Scheme Reference: TR010037
Unique Reference: 2002 8396

Purpose of representation

- 1. Comments on any additional information/submissions received by Deadline 2.**
- 2. Comments on Progressed SoCG.**

1. REP2 -007

Drawing Number: HE551492-GTY-LLO-000-DR-BL-30006	Rev: P04
--	----------

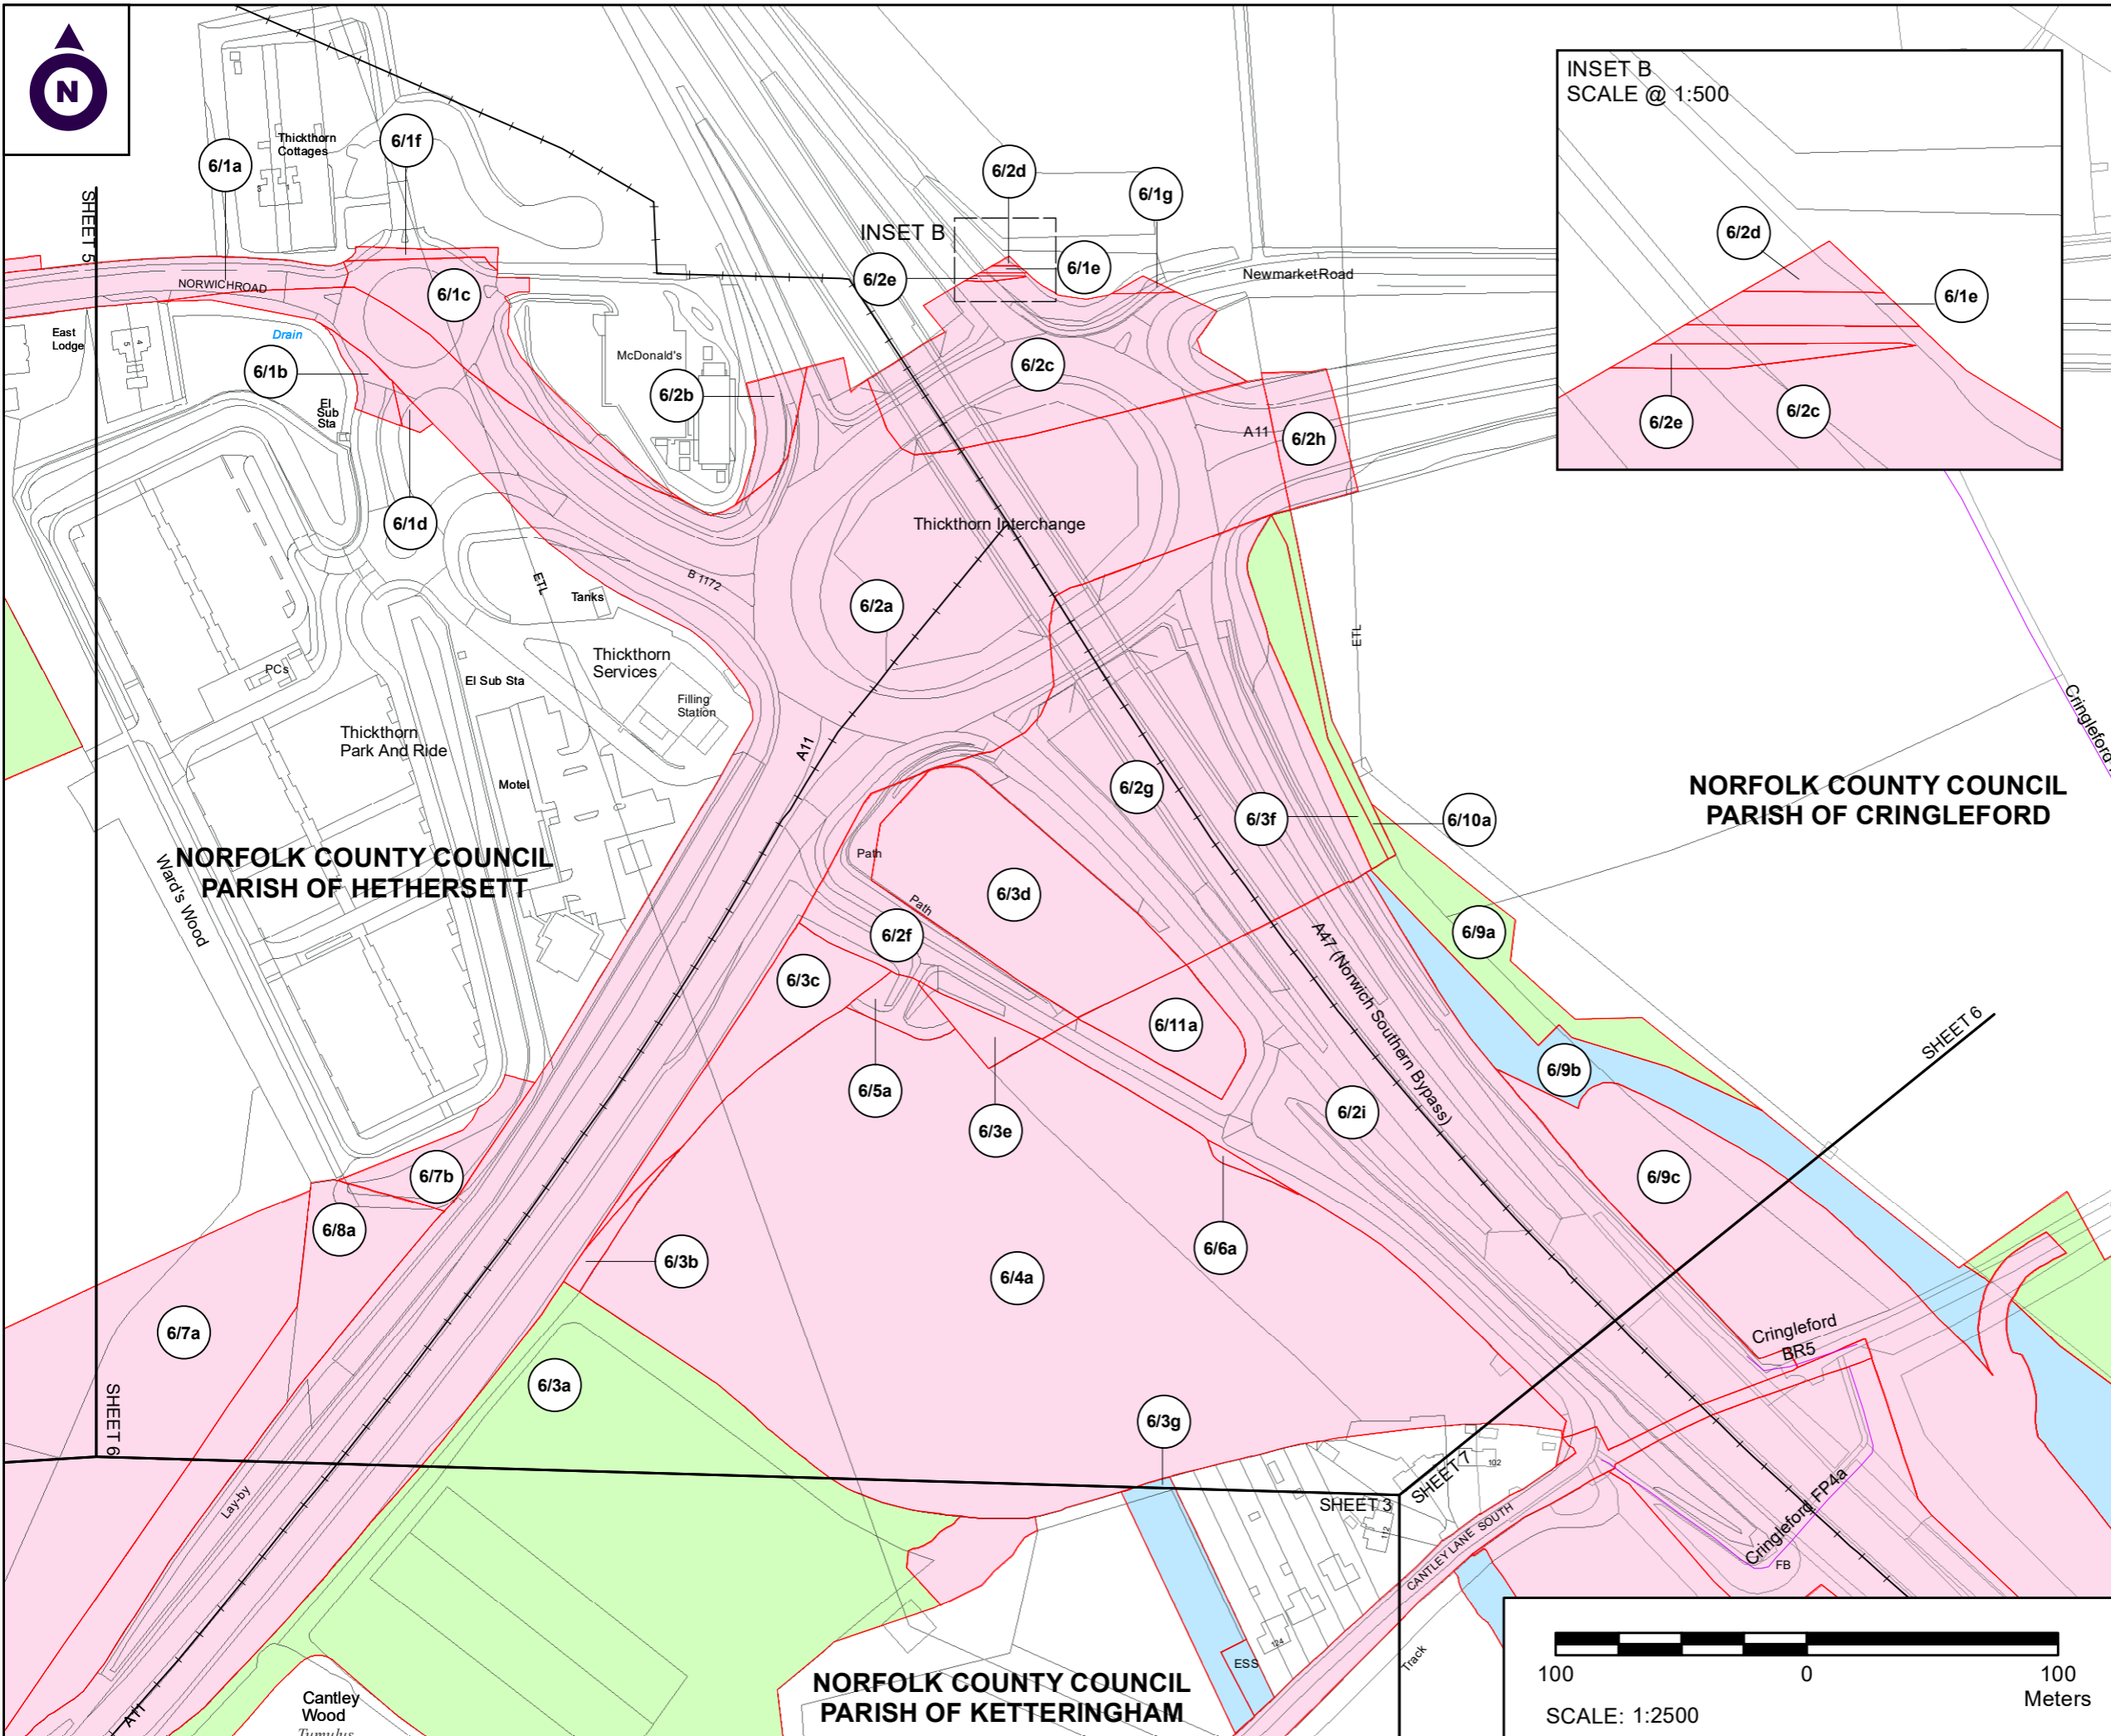
The answer from the Applicant, that plot 7/7c is the area required for the scheme at this stage in the design process is understood, but we remain concerned that the Applicant indicates there is no alternative location for the welfare facilities.

We are not convinced the Applicant has tried hard enough to find an alternative solution and simply referring this to a financial settlement is unsatisfactory. The owner does not consider the Applicant's scheme should be able to prevent or delay the construction and sale of much needed housing.

The Applicant has indicated in meetings that there is insufficient land within the scheme Red Line to provide an alternative location for the facilities, whereas we suggest it may well be possible for alternative land to be made available.

As the plot reference 7/7c will occupy land designed for three houses, after the Applicant has left site, the owners will have to ensure reasonable ground conditions remain and that there are no unintended consequences from the occupation, whether compaction, new contamination from fuels or otherwise relating to construction contract penalties and excess preliminary costs.

If the site (plot 7/7c) is to be used for welfare facilities with portaloos and an office or welfare base, it seems unlikely that the site needs to be 1.7 acres.

- along the hard surfacing of Cantley Lane, a closed off road used for public access, which can be maintained with a temporary diversion.
- on a site limited to the south of the overhead UKPN overhead pylon line which is reserved for public open space after completion. It would not prevent construction, and the delays would be reduced.

If the Applicant can persuade their contractors, or they can be pressurised to omit this area or time limit their occupation, we request that a deadline is set for removal of the compound so the landowners can provide guarantees to contractors and house buyers.
